Application for Removal or Variation of a Condition following Grant of Planning Permission or
Listed Building Consent

Site Of Former Beverley St Nicholas Primary School Juniors

Erection of 30 dwellings with associated parking, works, and infrastructure following demolition of former St. Nicholas Junior School

21/02391/PLF

Drawing title
Proposed East Elevation
Proposed Material Spec

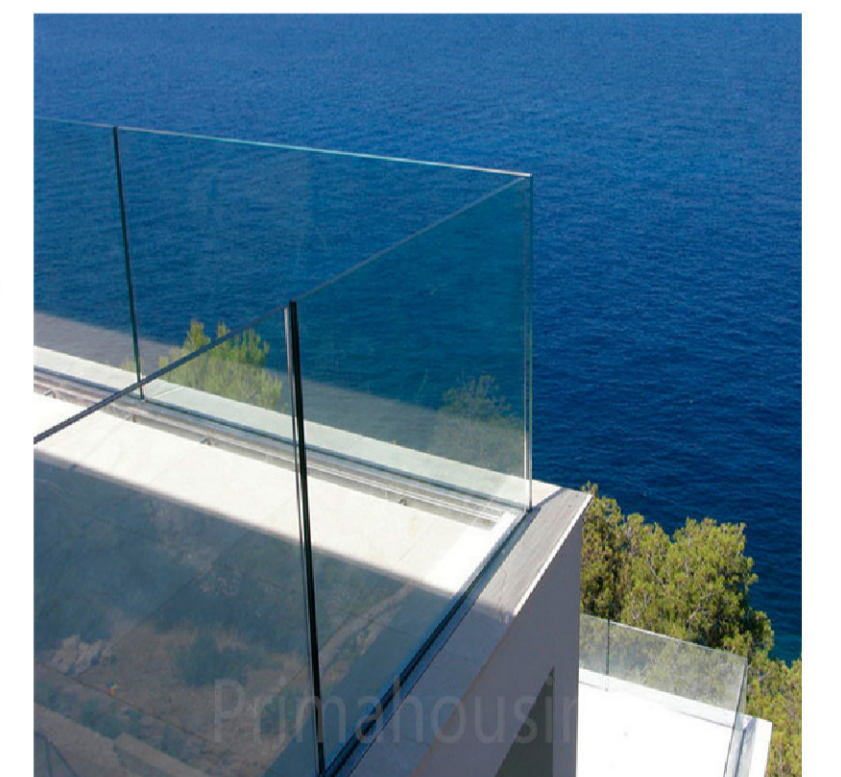
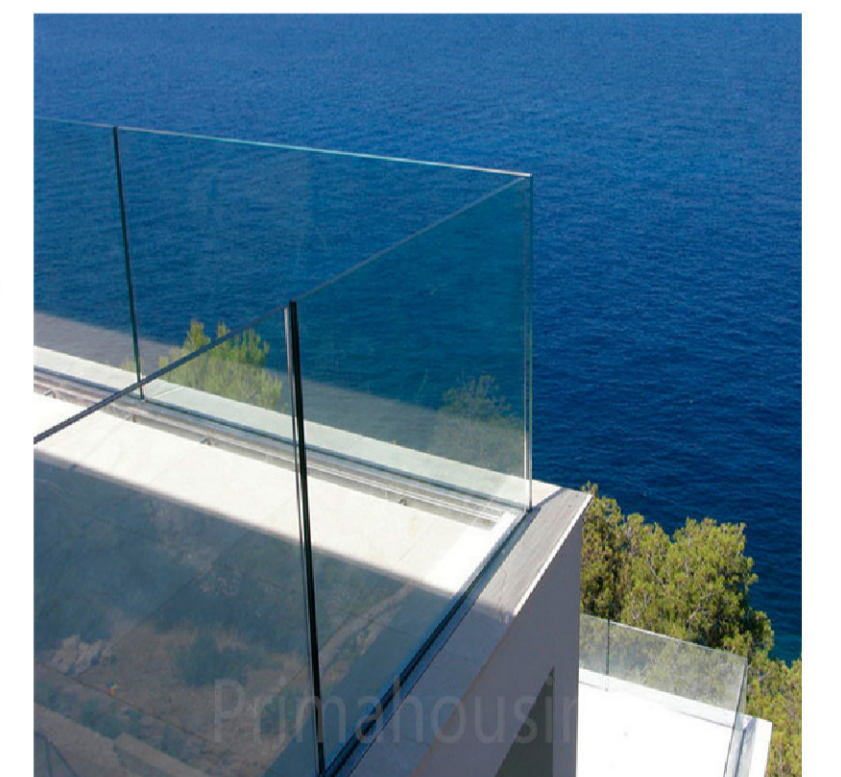
Condition 11 to be varied to allow an amendment to the parking layout
Condition 22 to be varied to allow changes to the site layout plan to improve the parking layout and the external material change from white painted brick to render.

Condition 11 to allow the replacement of the site layout plan
Condition 22 to allow the replacement of the site layout plans and elevation and cross-section plans
